Consultation response from KC PROW (footpaths)	
2023/91116 Land off, Primrose Lane, Hightown, Liversedge, WF15	
Erection of 67 dwellings	
Date Responded : 13/7/23	Responding Officer : Giles Cheetham
<p>Kirklees PROW objects to the application as made. Amended and new submissions may address concerns raised.</p> <p>Kirklees PROW welcomes the proposed connectivity to public bridleway Primrose Lane (Spe/111/120), however these links should be appropriately provided for multi-modal use (not motor-vehicular). The proposed link alignments from the estate footway/roadway should generally avoid right-angled bends in them. Routes should be appropriately secured for use in perpetuity, either through formal agreement, condition or other requirement.</p> <p>Public paths through the development should be improved through widening and appropriate construction works, e.g., to the south and east sides of the development, footpath provision should be at least 2 metres wide, and wider where enclosed by high boundaries on both sides. The submitted proposals do not match reasonable expectations for new developments. Some relevant paths are within the identified site boundaries, some relevant paths are

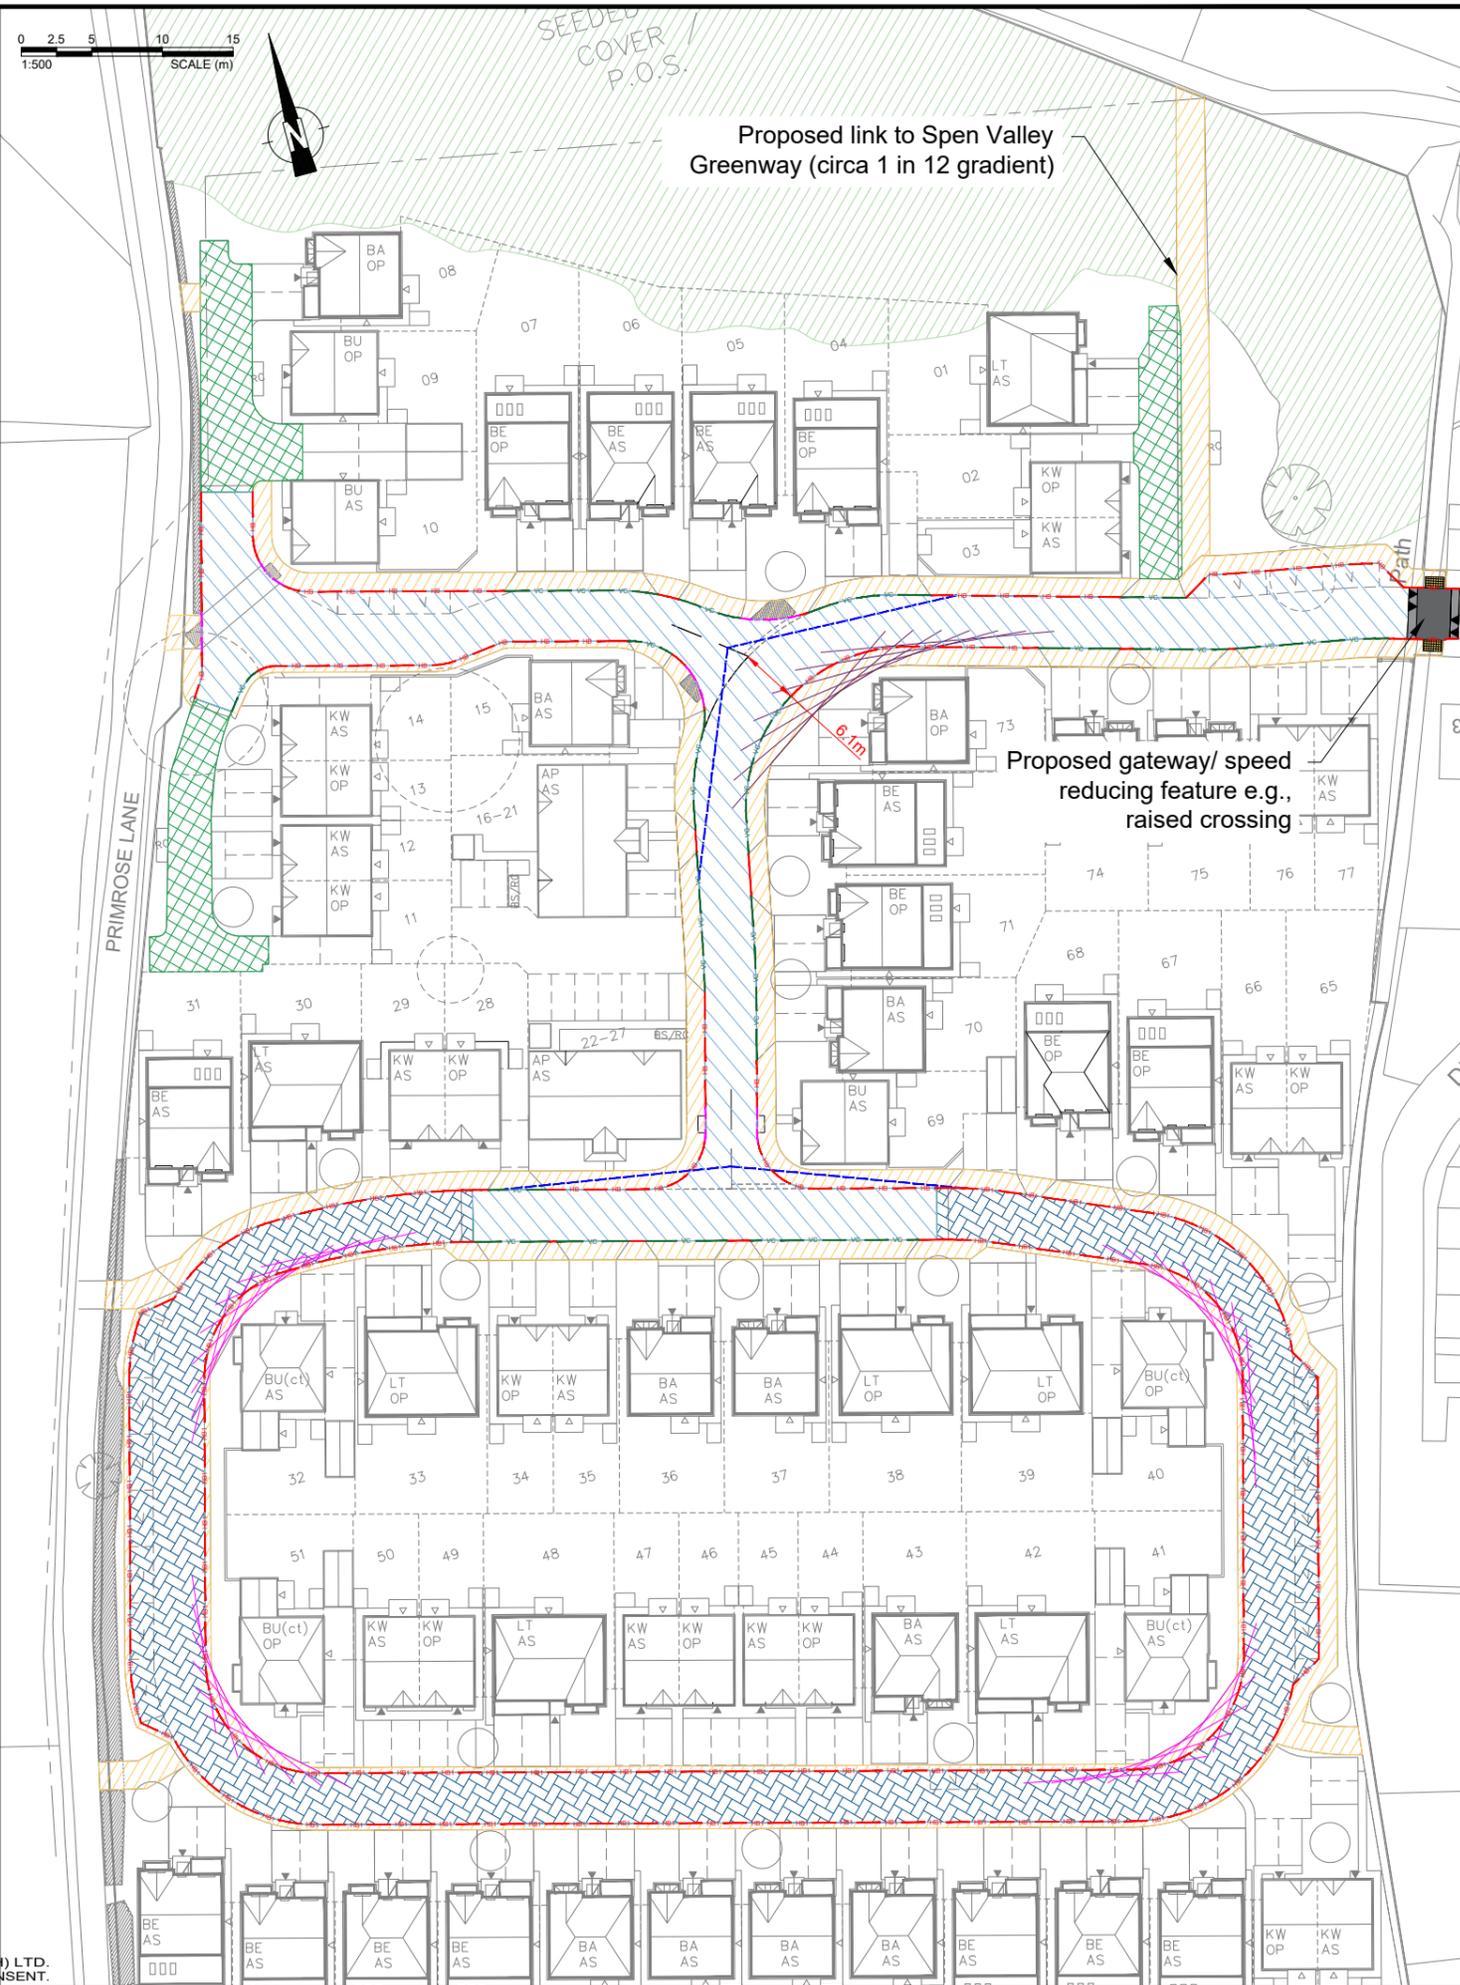
Provision of new routes may potentially be by condition, with appropriate triggers for submission of details, agreement, implementation and retention.

Submission of details for the construction and provision of improvements identified in these comments would be required.
